Your ref: 3/2018/0362 and 0363

Date: 15th June 2018

Planning Application 3/2018/0362 and 0363: Conversion of the former Punch Bowl Inn (Grade II listed building) into 5 Holiday Lets and Café, including demolition and extensions. New pitch holiday lodge park with 15No units within curtilage; Former Punch Bowl Inn, Longridge Road, Hurst Green BB7 9QW

Former Punch Bowl Inn - Longridge Road, Hurst Green, Clitheroe.	28/06/2011
Proposed re-development to form holiday lets/cafe for Mr A Donelan.	2765
1:100 @ A3	SK/00/1

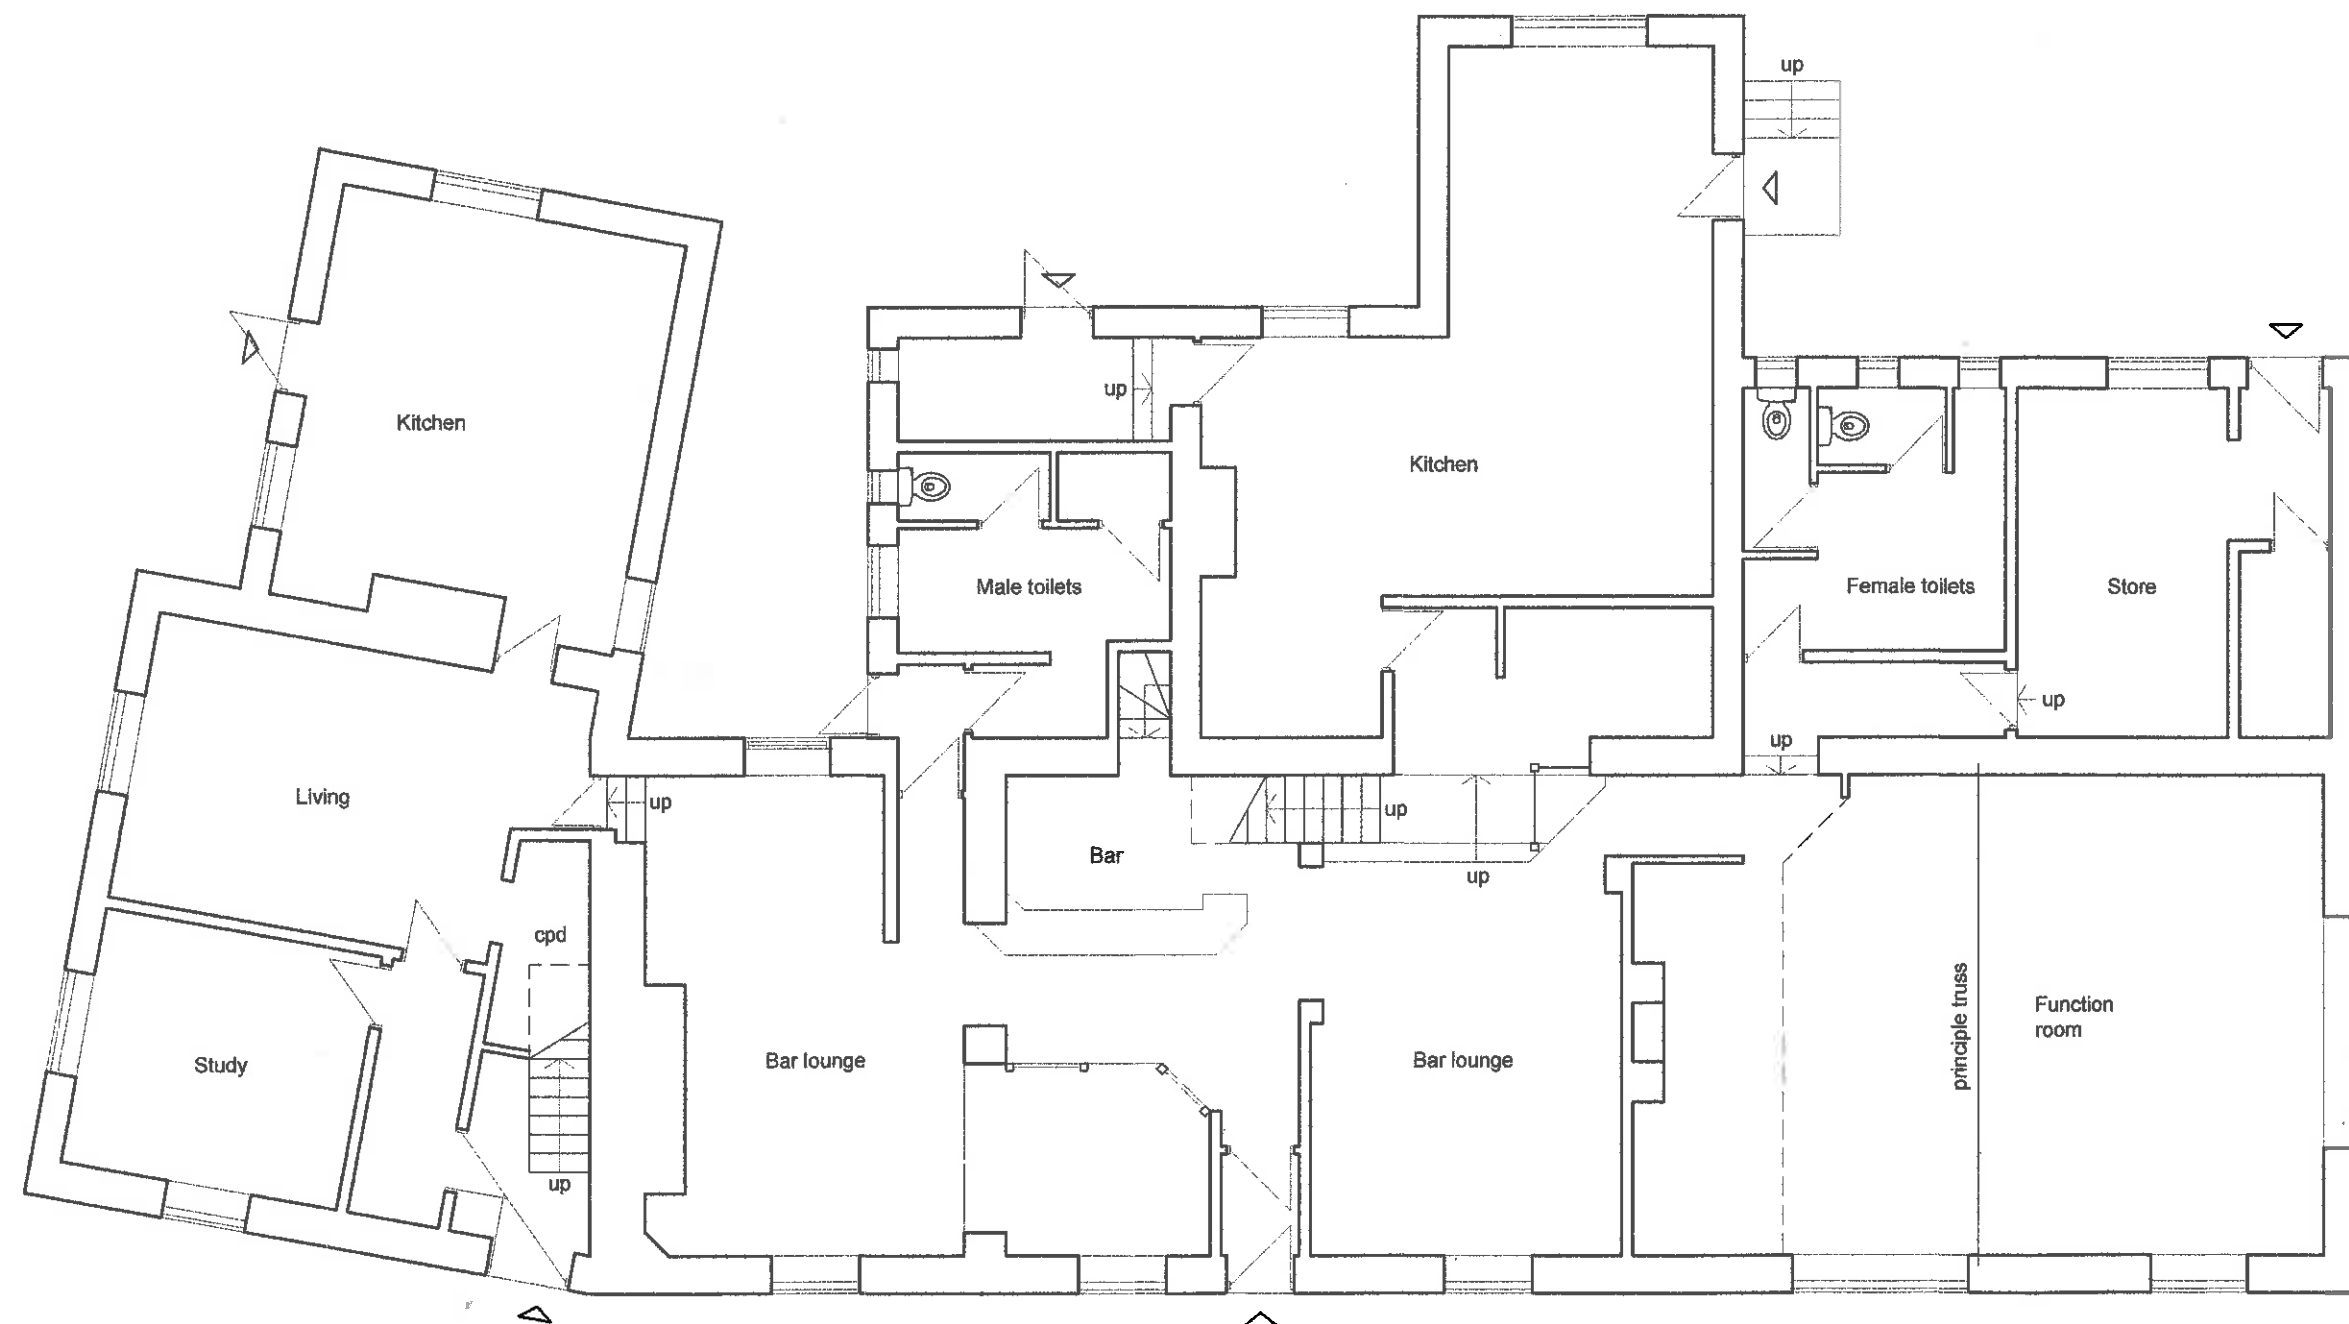
- (i) The loss of the rear barrel vaulted cellar (unless this can be shown to be modern);
- (ii) The loss of much of the rear wall of the right-hand former barn section and partial demolition of the outshut under the catslide roof;
- (iii) The loss of the rear stair in the former cottages and the subsequent changes to the circulation pattern; and
- (iv) The works required to eradicate and repair the dry rot and other damage that has occurred to the building.

We would again recommend that further information is obtained from the applicants before the application is determined. This should include a more thorough assessment of the elements of the building to be altered or repaired and the impact of the proposals upon them. Further details of the rot and other damage to the building and the extent of repair works to the historic fabric required should also be provided.
